REF: Notice of Application, SE-21-00017

I'd like to comment about the subject Proposal and list some questions. As well as clarify a road issue, as shown on exhibit 2, Clear View Concept Plot Map as envisioned by Encompass, May 2006. This plot layout and its Vicinity Map indicate the property is directly accessed from the North via Stoneridge Drive and then Whisper Creek Drive (both are private, asphalt improved roads) and then is bounded on the south by Fowler Creek Road. However at one point Fowler becomes Pasco Road – which does actually border subject land to the south, via an short, steep hill side. Fowler and Pasco Roads are county roads. Pasco and east half of Fowler Road are low use, dirt, unimproved roads.

**CLEAR VIEW ACRES SHORT PLAT
KITITAS COUNTY SHORT PLAT NO. 06-XX
PTN. OF THE WEST 1/2 OF SEC. 1, T.19N., R.14E., W.M.
KITITAS COUNTY, WASHINGTON**

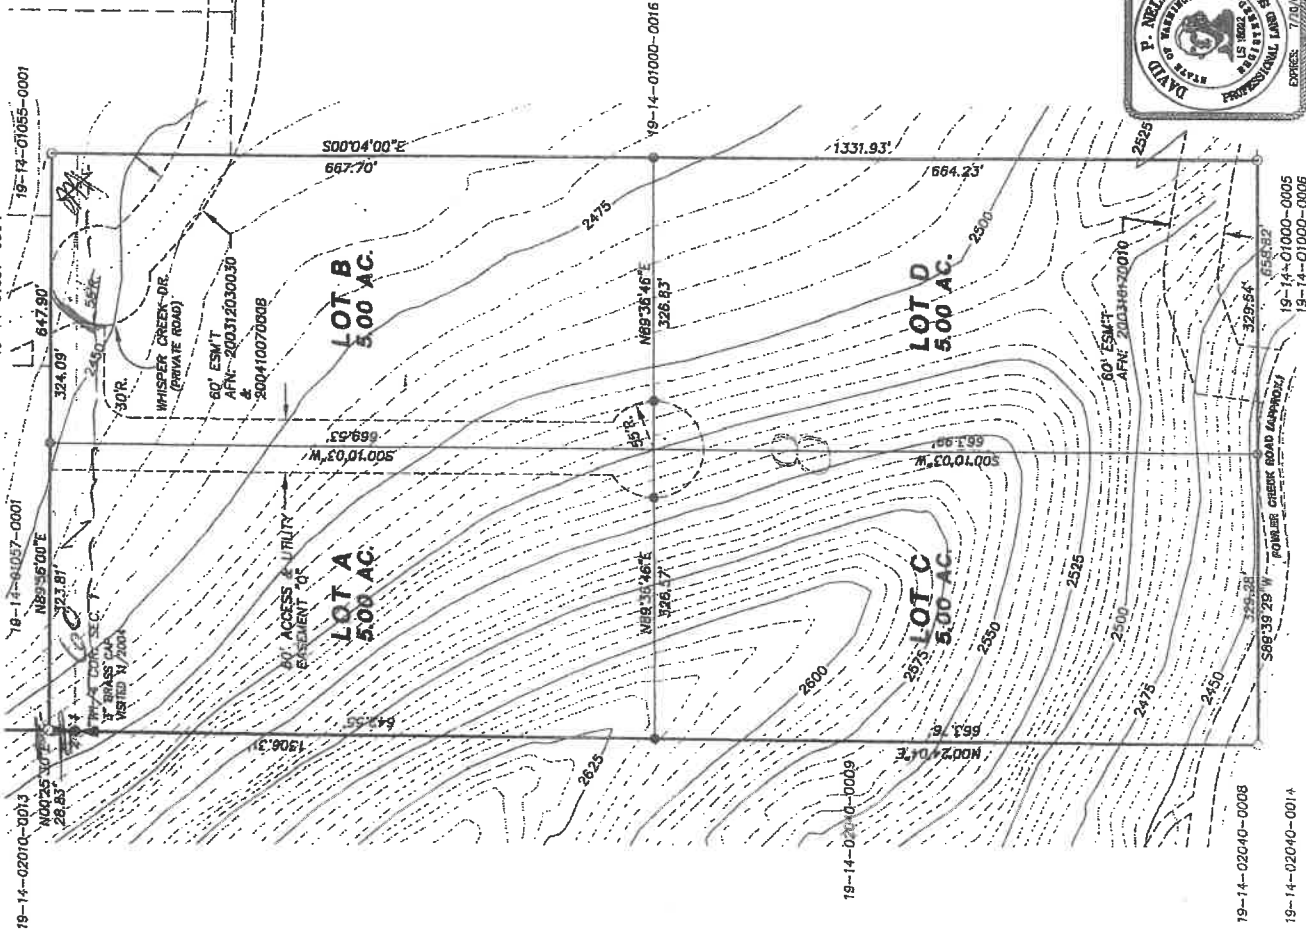
We do have concerns about how the included plot designs showing easements along this property and Pasco Road; for what? Utilities? Why?

They also show a 60' and 3' Easement running along east boundary, north to south. Why? Why such a wide easement? Especially when the provided Plot Map as well as current satellite photos shown a rough access road running north to south, right down the middle of subject property, providing perfect easement to the four proposed five acre lots. This initial rough cut road runs from Whisper Creek Road south over about 5/8th length of this subject property. Perfect ingress/egress and utility access to these four lots. Especially when the home owner accession (HOA) has allowed Blue Span Communications to install Fiber Optic cable along Stone Ridge Drive and Whisper Creek Drive.

My concern is the odd 63' of easement along east lot line. As well as possible impact on Pasco Road. As long as we can be assured of no vehicle ingress/egress from Whisper Creek Road to Pasco Road; there are no majors issue with this application. To a degree, even an utility easement might be agreeable. Any impact to the steep ridge along south boundary and Pasco Road would be of a concern.
